**Director-General's Requirements –
Environmental Assessment for the
West Cliff Mine Water Supply Project**

The Department has received your application for the West Cliff Mine Water Supply Project in the Wollondilly local government area (reference number: 06_0288).

PROPOSED WATER SUPPLY PIPELINE – WESTCLIFF COAL MINE

ENVIRONMENTAL ASSESSMENT REQUIREMENTS
PROPOSED WATER SUPPLY PIPELINE – WEST CLIFF COAL MINE

Figure 1: Vocsidizer Plant water supply route from Appin Mine to West Cliff Mine.

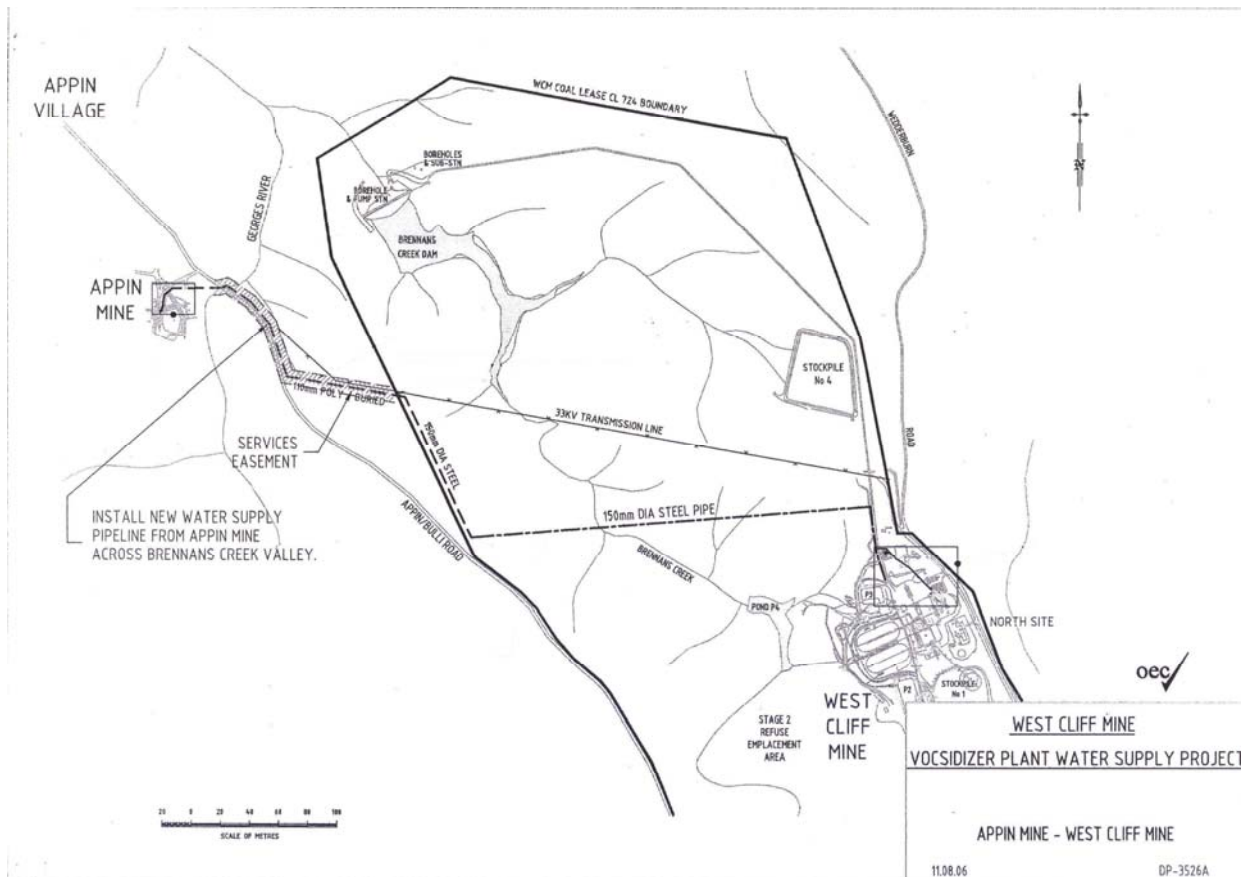
I note Section 4 of the preliminary environmental assessment that Appin Mine is described as being within Zone No. 4(c) – Light Industrial Service. This is not correct. Under Wollondilly Local Environmental Plan, 1991 the area of Appin Mine identified on Figure 2 is located within the Rural "A1" Zone.
